# CITY OF ALBUQUERQUE

June 2, 2021

**Re: Stripes On Lomas  
6121 Lomas NE  
Traffic Circulation Layout  
Architect's Stamp NONE PROVIDE (J18-D021A)**

TCL1

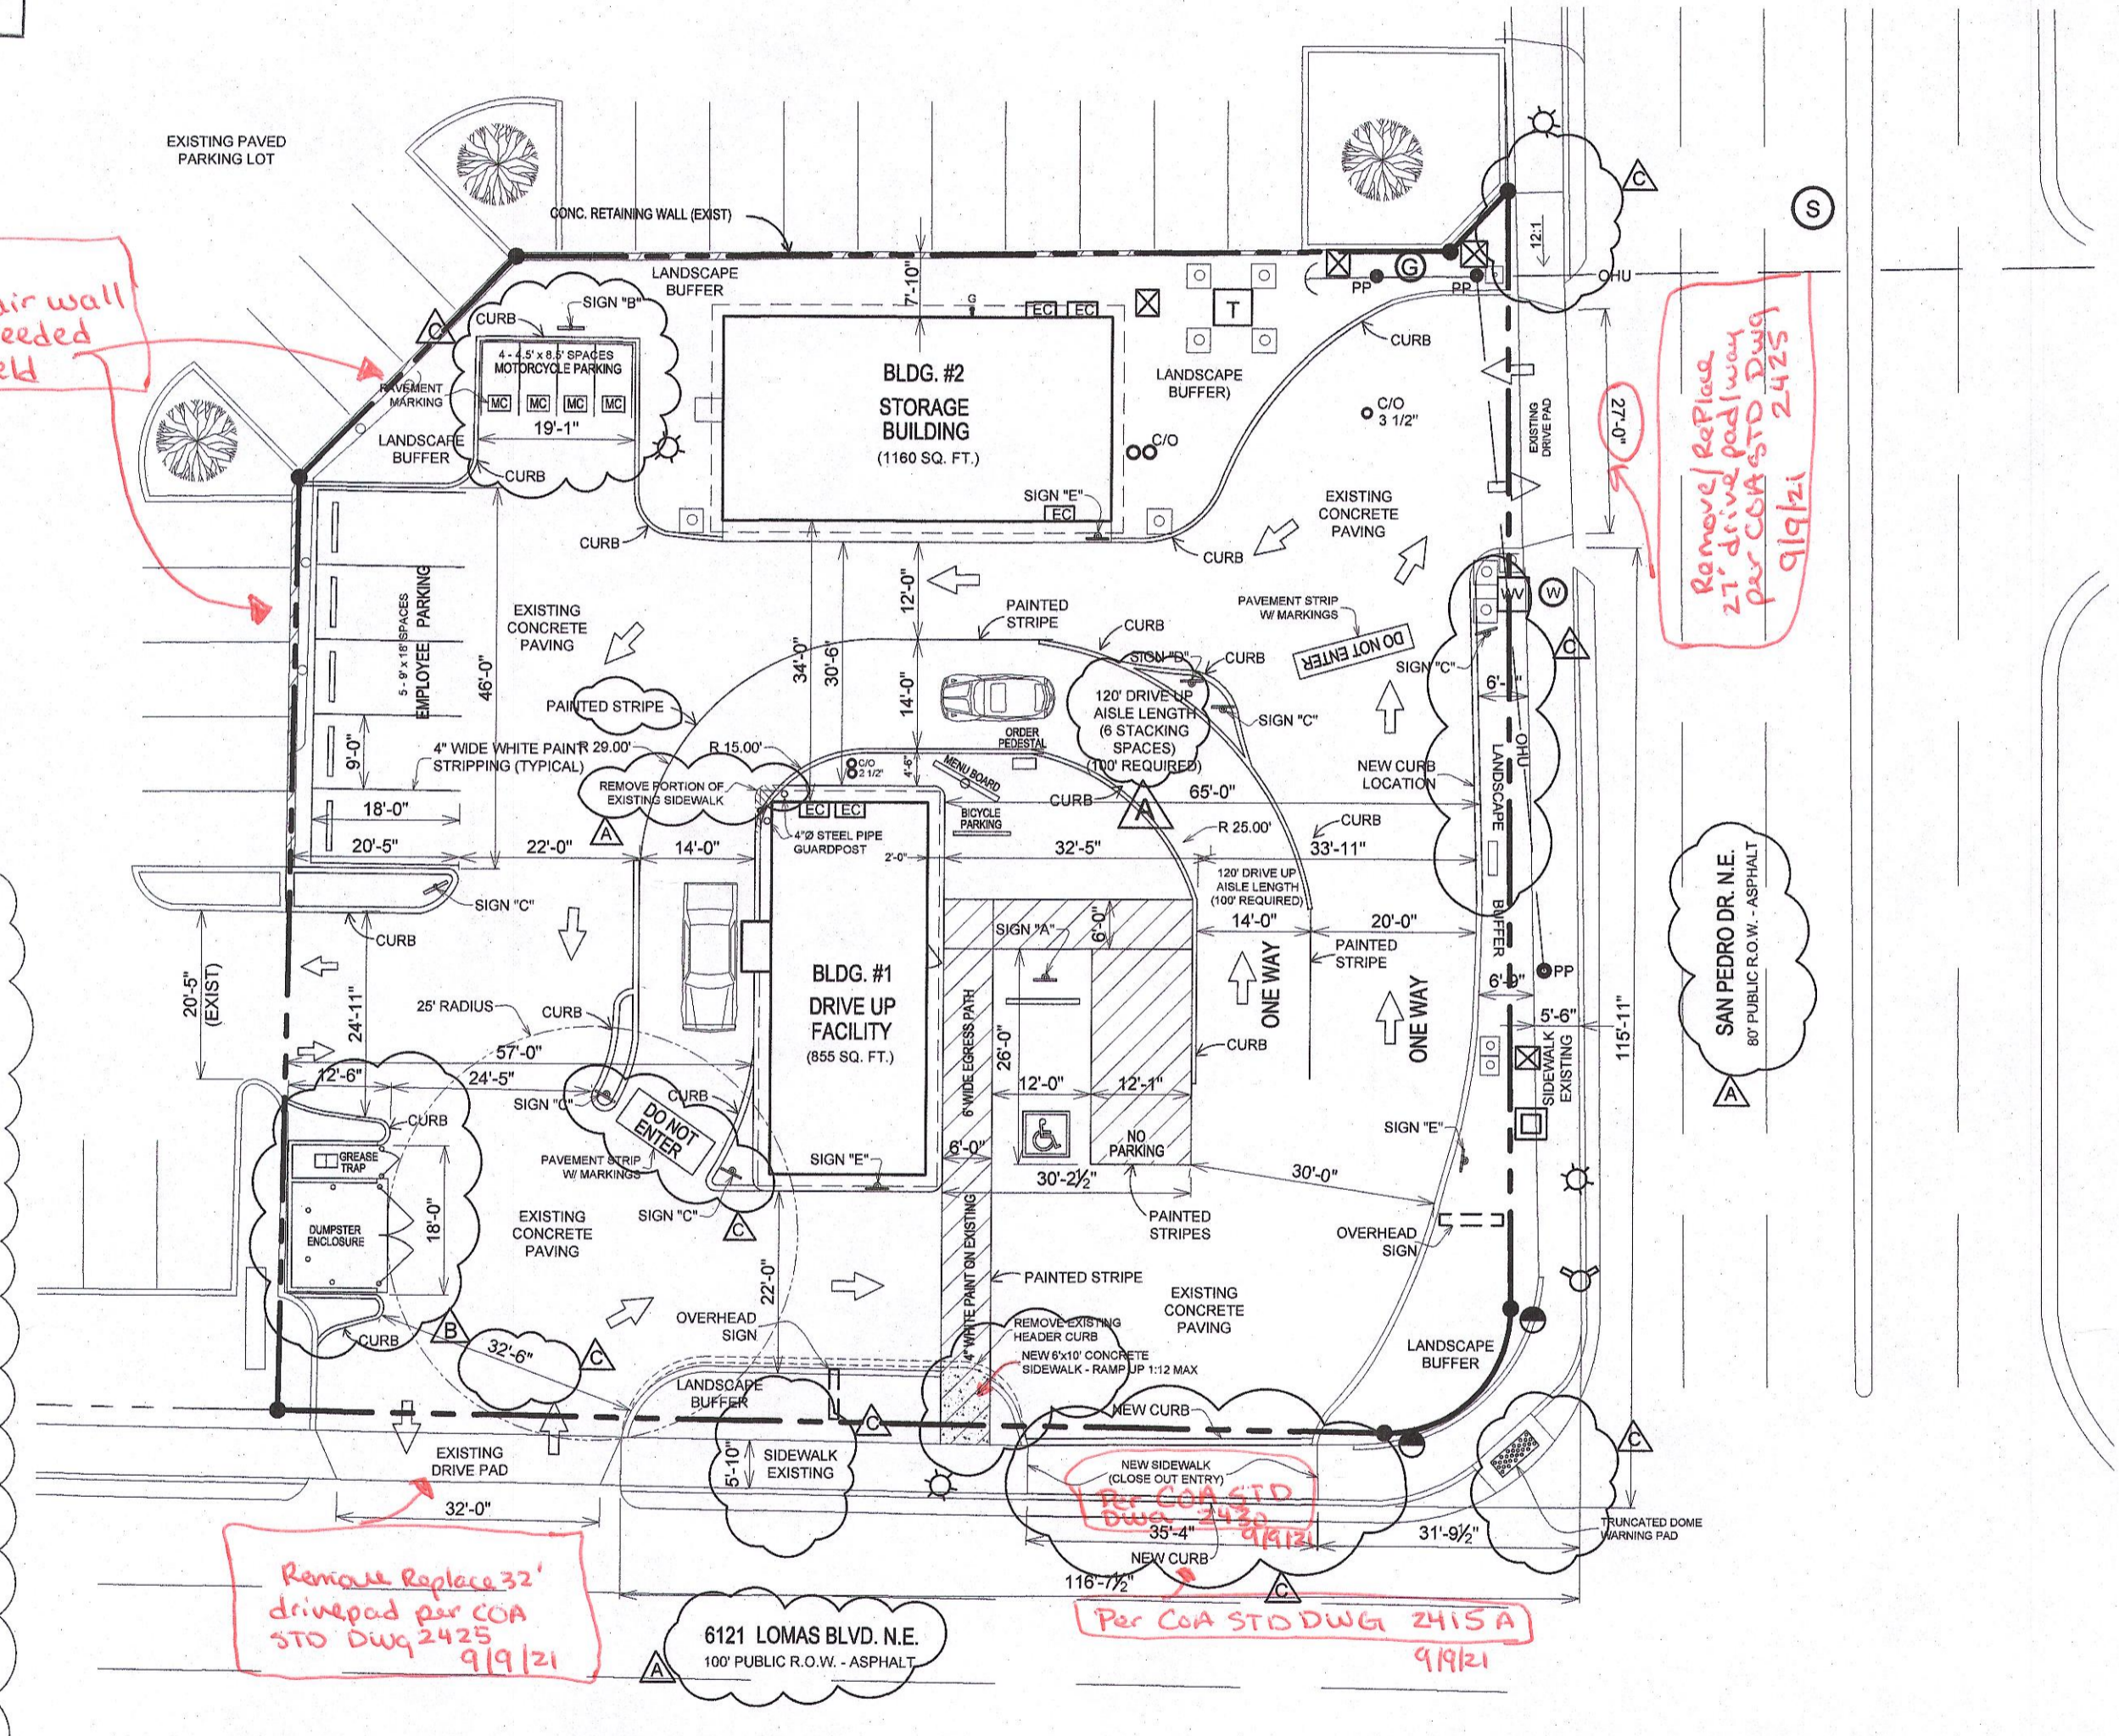
1. List the number of parking spaces required by the IDO as well as the proposed number of parking spaces including bicycle and motorcycle parking and **discuss with Zoning.**
2. The traffic circulation layout must be **dated (current date not expiration date)** by an engineer or architect licensed in the state of New Mexico.
3. Please identify all existing buildings, **doors**, structures, sidewalks, curbs, drive pads, wall and anything that influences the parking and circulation on the site.
4. Identify all existing access easements and rights of way width dimensions.
5. **Maximum access width for arterial, collector, and local streets are as follows:**

6. What does the **triangle with the Letter B** signify?
7. Adjacent to the triangle Letter B, there is proposed curbing next to proposed Dumpster Enclosure, **this curbing will reduce the driveway/pad width and push vehicles towards the center of the entrance drive. Please address if this might be a traffic safety concern for ingress and egress vehicle movement.**
8. Please list the width all existing drive aisles. Some dimensions are not shown. **Especially adjacent to the Dumpster Enclosure location.**
9. ADA curb ramps must be updated to current standards and have truncated domes installed fronting the intersection corner of Lomas Blvd and San Pedro. You will need to verify the ramp is ADA compliant.

10. **All proposed ramps on site will need details**
11. **The existing driveways fronting Lomas Blvd and San Pedro Drive will need to be replace since they are not current/update ADA accessible.** A construction note will need to be provided for the removal/replacement of these driveways. Suggest the Lomas driveway closes to the intersection be closed because of its proximity to the intersection doesn't meet DPM criteria (Site Access Points: Minimum Distance from Commercial Site Access Points to Intersection table) and it is traffic safety concern.

12. **The proposed 4" steel pipe guardpost will need to be paint yellow.**
13. **Motorcycle parking spaces: Label each stall pavement MC.**
14. All bicycle racks shall be designed according to the following guidelines:

18. Show all drive aisle widths and radii. Some dimensions are not shown.
19. **The minimum drive aisle dimensions are shown below**

Minimum Drive Aisle Width
<b>Two Way Traffic</b>	<b>22'</b>
Main Circulation Road	24'
<b>Fire Lane</b>	<b>20'</b>
20. You have two drive aisles that are less than 20 ft in width (18'-4 1/2", 9'-5"). **These will need to be addressed and for two way traffic you have 20'-5" into adjacent lot (should be 22 ft).**
21. List radii for all curves shown; for passenger vehicles. Radius for delivery trucks, fire trucks, etc. is 25 ft. or larger.
22. Per the IDO, a 6 ft. wide ADA accessible pedestrian pathway is required from the public sidewalk to the building entrances. **Please clearly show this pathway and provide details on the proposed ADA sidewalk/ramp. This proposed ramp will need to**

**have a 5x5 2% landing so verify that the existing drive aisle complies with this requirement or the Lomas sidewalk is 2%.**

25. All one-way drives shall have "One Way" and "Do Not Enter" signage and pavement markings. **Please show detail and location of posted signs and striping. Provide details of the pavement markings and sign face (All will need to be provided, especially for the one-way orientation).**

26. Any private structures that are located within public right-of-way such as fences and walls shall either be removed or else a revocable permit with the City is required in which an annual fee is paid per year, based on square footage of the encroachment. **The OVERHEAD SIGN fronting Lomas Blvd is encroaching onto COA ROW. Verify that the existing overhead sign fronting San Pedro Drive is not encroaching into COA ROW (Includes air space).**

30. I would prefer that you close the existing 30 ft Lomas entrance/driveway closes to the intersection. Main concern is the driveway que line might back up into Lomas causing a traffic safety issues and the proximity to the intersection is also a traffic concern. Per DPM only certain driveways will be allowed off public streets.

6 BIKE RACK DETAIL
 SCALE: 3/4" = 1'-0"

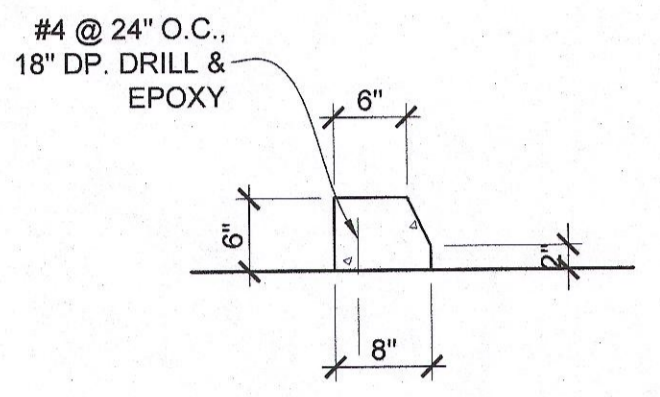
- a. The rack shall be a minimum 30 inches tall and 18 inches wide.
  - b. The bicycle frame shall be supported horizontally at two or more places. Comb/toaster racks are not allowed.

- c. The rack shall be designed to support the bicycle in an upright position. See the IDO for additional information.
  - d. The rack allows varying bicycle frame sizes and styles to be attached.

- e. The user is not required to lift the bicycle onto the bicycle rack.
  - f. Each bicycle parking space is accessible without moving another bicycle.

15. Bicycle racks shall be sturdy and anchored to a concrete pad.
16. A 1-foot clear zone around the bicycle parking stall shall be provided.
17. Bicycle parking spaces shall be at least 6 feet long and 2 feet wide.
